6/26/12

# Plot Plan

# # 351-A-28

SITE PLAN FOR:  
LOT 13 ORCHARD GREEN  
SHEPHERD LANE, PORTLAND, ME.  
OWNER/APPLICANT:  
KASPRZAK, INC.  
ROUTE 5, N. WATERBORD, ME

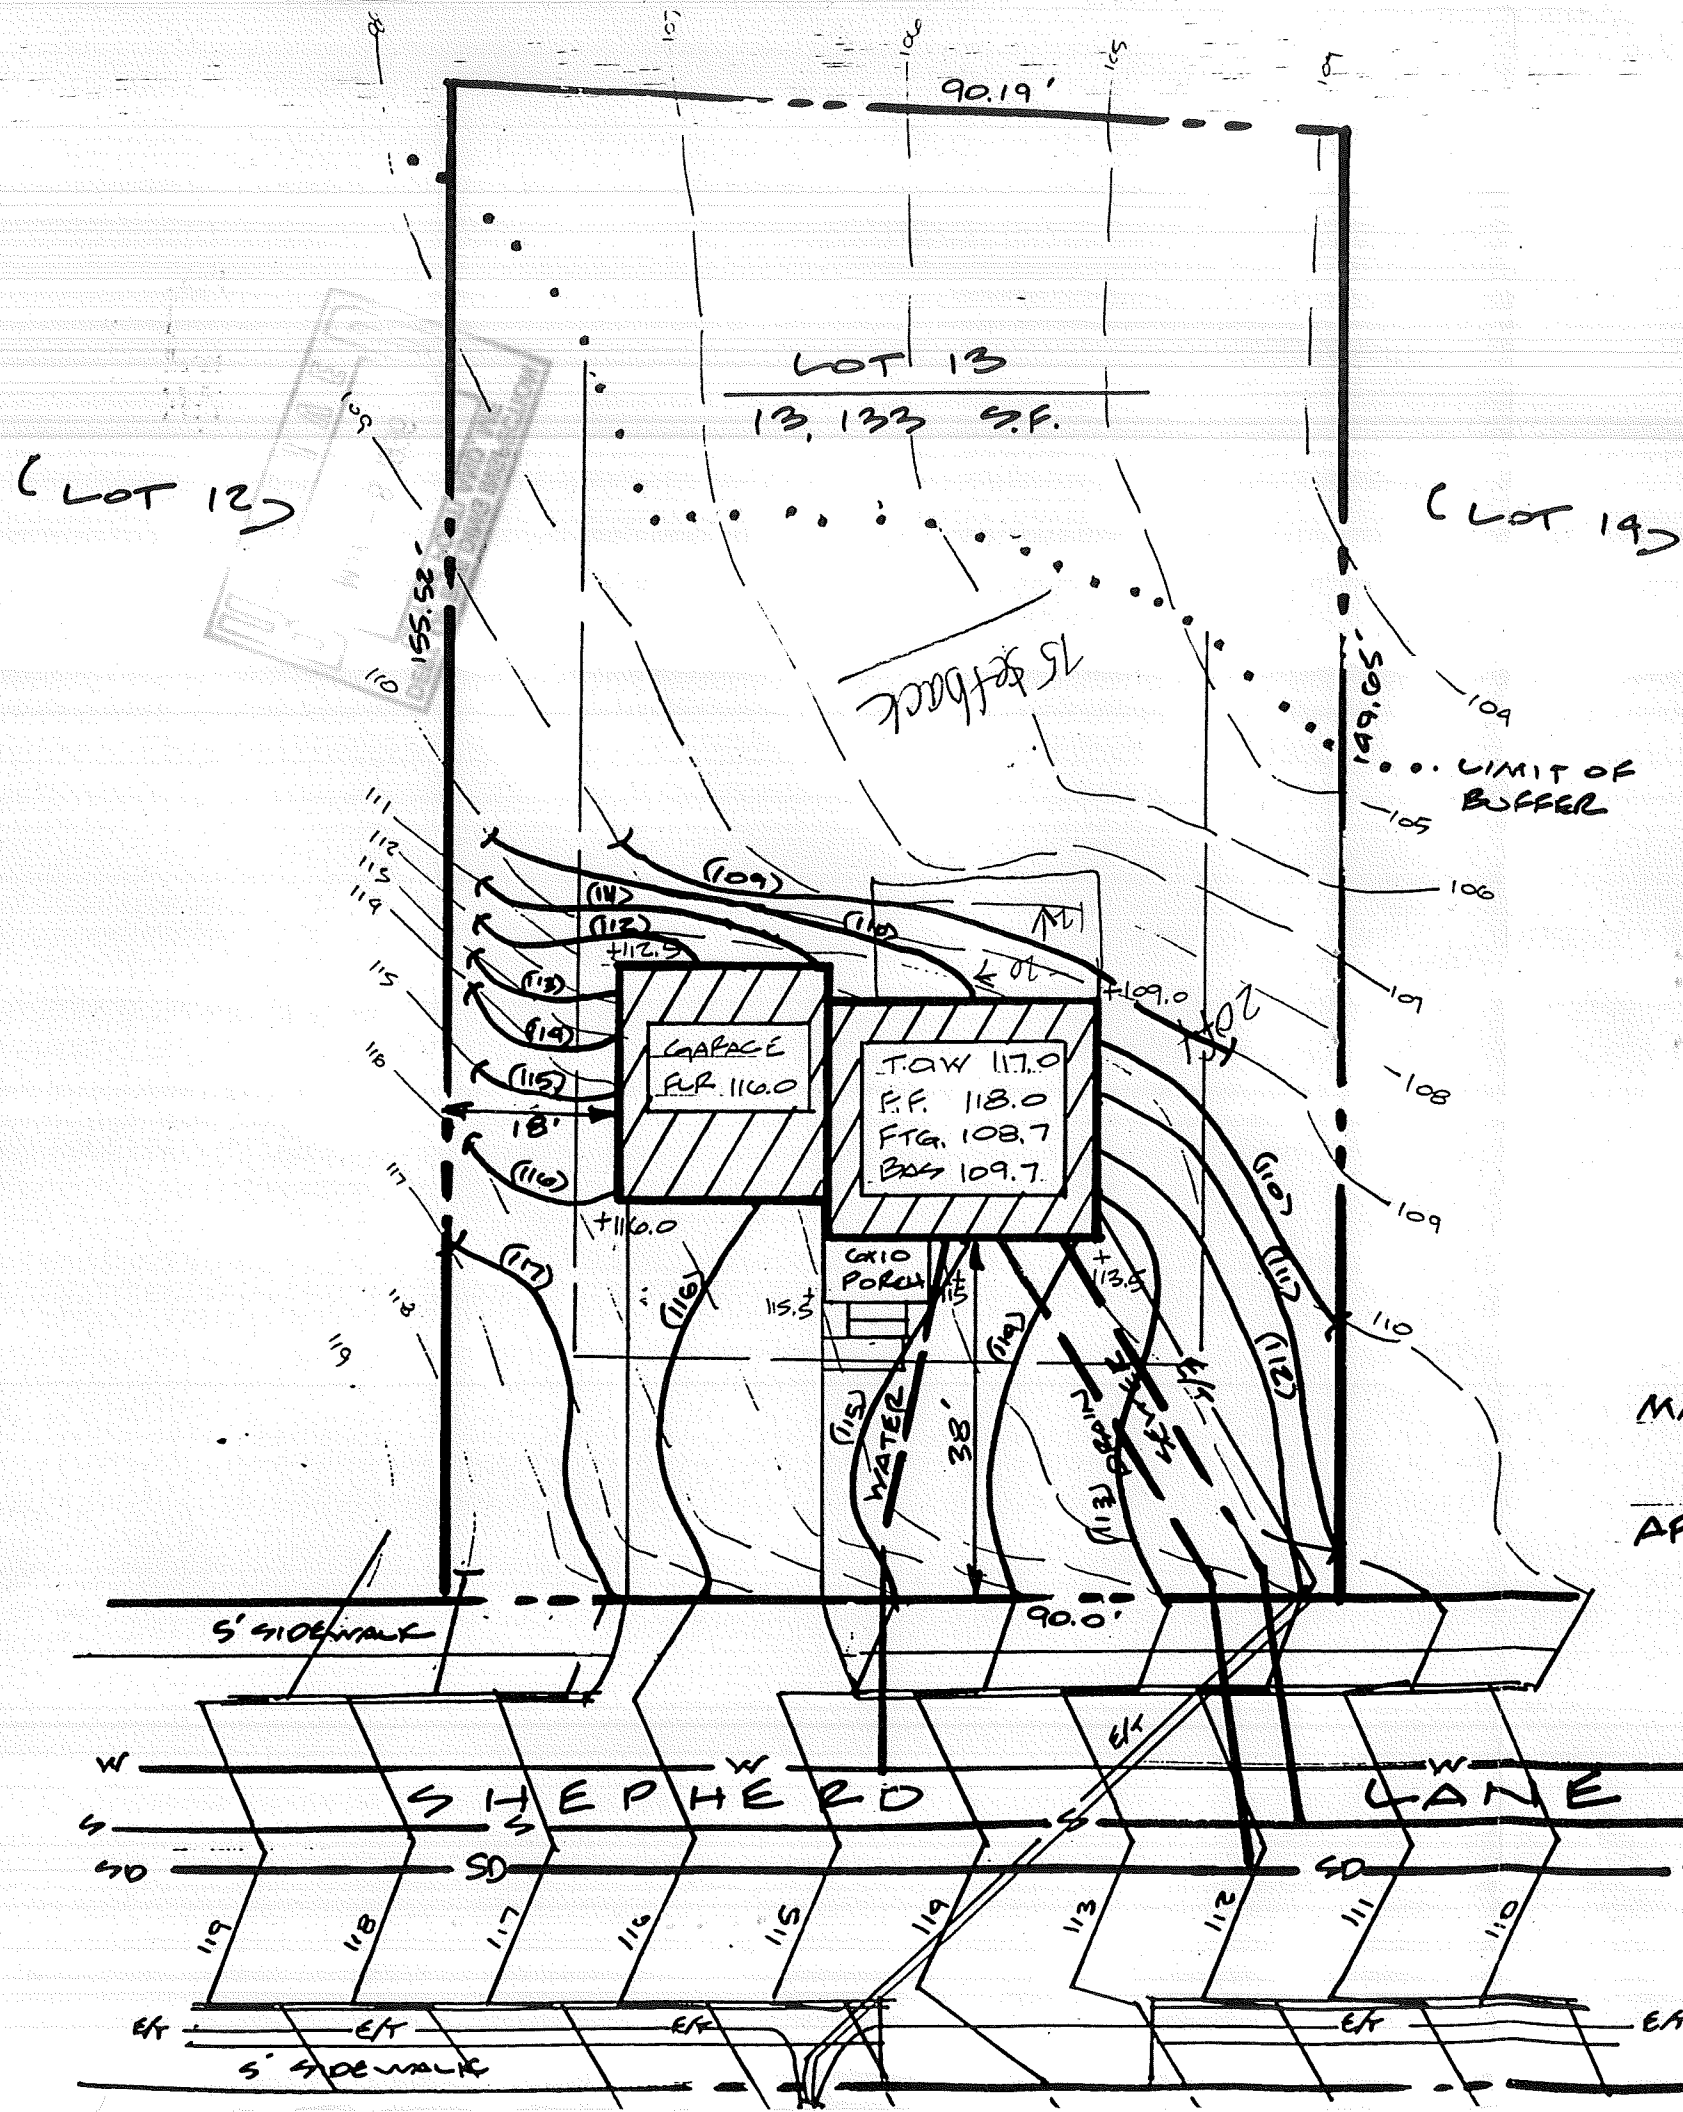
I was in error on my condition for the rear deck. It was permitted in 1996

Requested permits for Deck & Shed

None shown on file part of conditions. This permit does NOT validate them

Assumed 10' to Rear PL  
Code Enforcement officer to verify 10' min setback
